Application No: FG/37/22/PL
Site Address: 61 Sea Lane Gardens Ferring BN12 5EG
Description of works: 1 No dwelling. This site is in CIL Zone 4 and is CIL Liable as new dwelling.

Thank you for your internet representation made on 3rd April 2022 which has been recorded as an objection with the comments as follows:

OWPC46087

EXISTING SITE PLAN 1:200

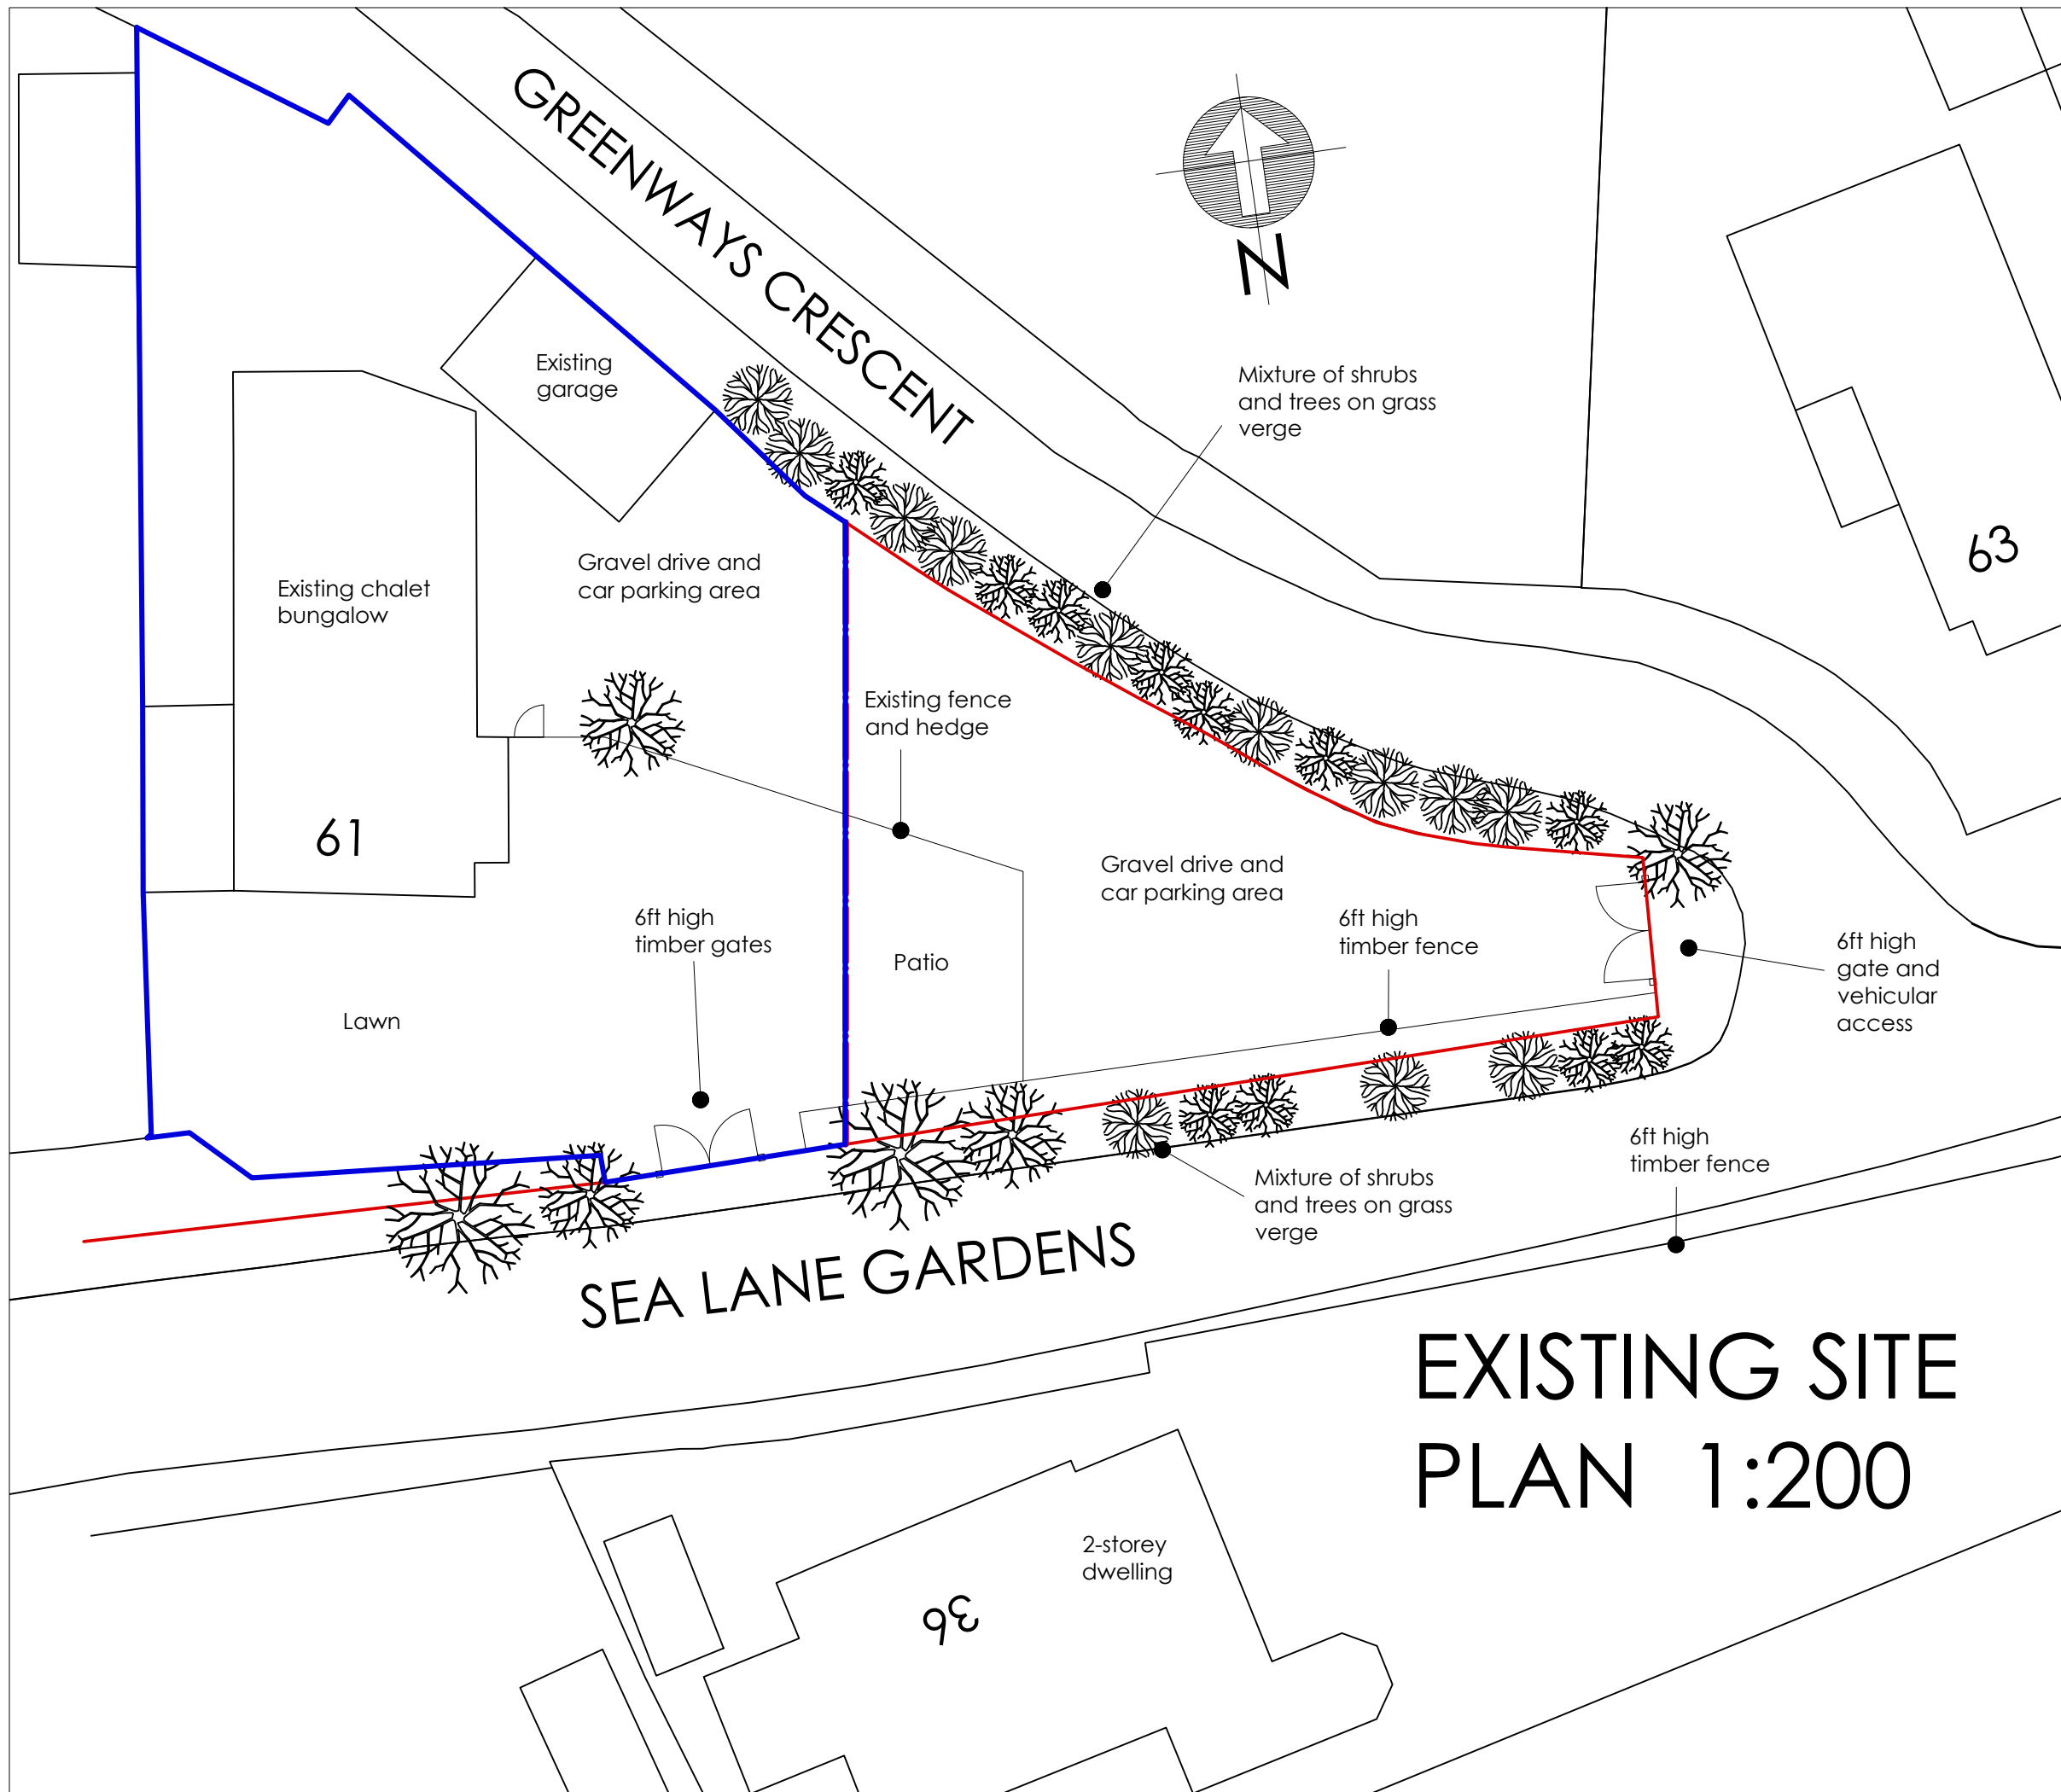
3. As shown from the block plan the areas with trees surrounding the plot on both Sea Lane Gardens and Greenways are not owned by no 61, and some have been lost due to the recent storm so they will not provide screening. No 61 have also recently cut down some trees on said land, again which they do not own.

# PROPOSED CAR PARKING PLAN 1:50

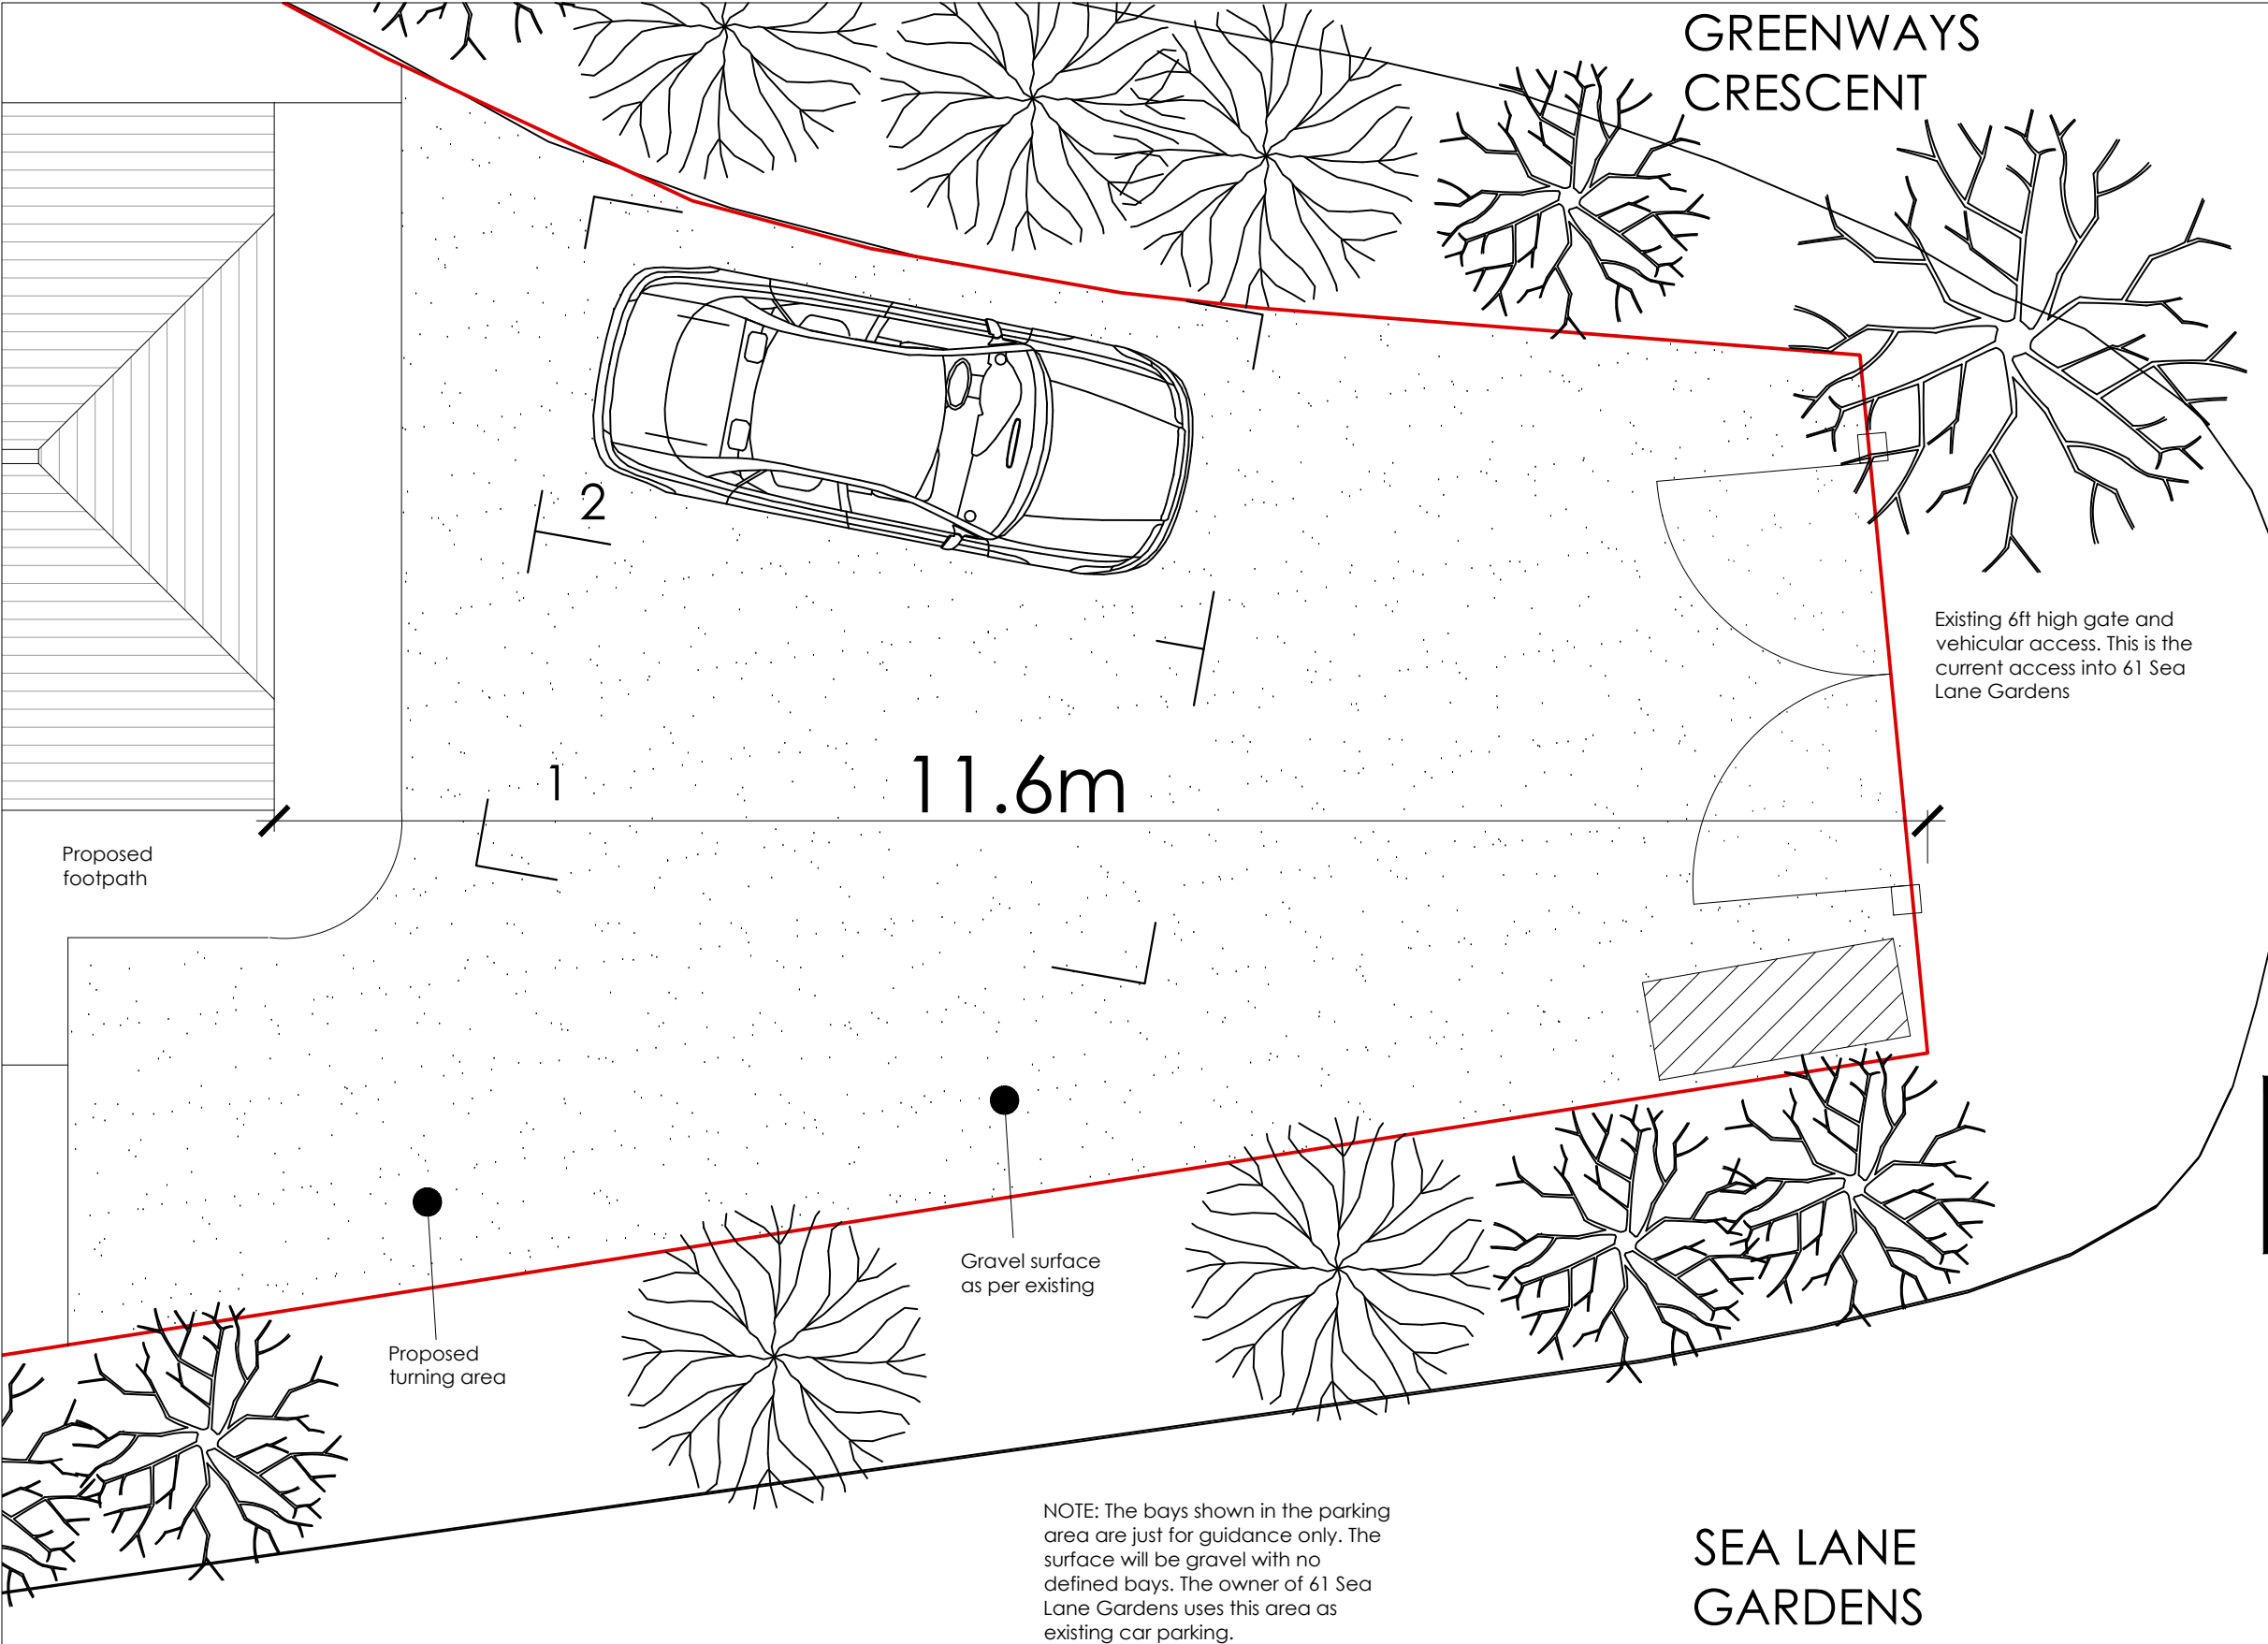
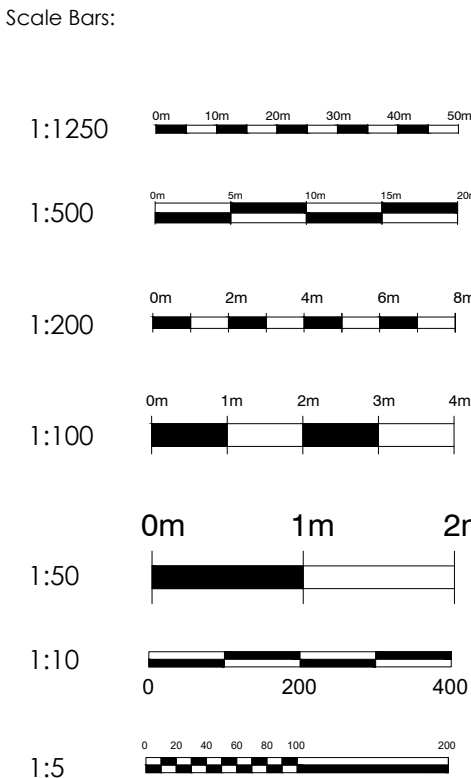
2. The plans say that the driveway for proposed property provides space for 2 cars and a turning space, however the space is on the plans is 11m and the average turning circle of a car is 10.6m, meaning that if two cars are parked they will have to reverse out onto a blind junction. Although the highways agency state the drive is already in the same position, the current property has a large drive with plenty of turning space meaning that cars are not currently reversing onto a blind junction - this needs to be looked at by the highways agency again with this in mind.
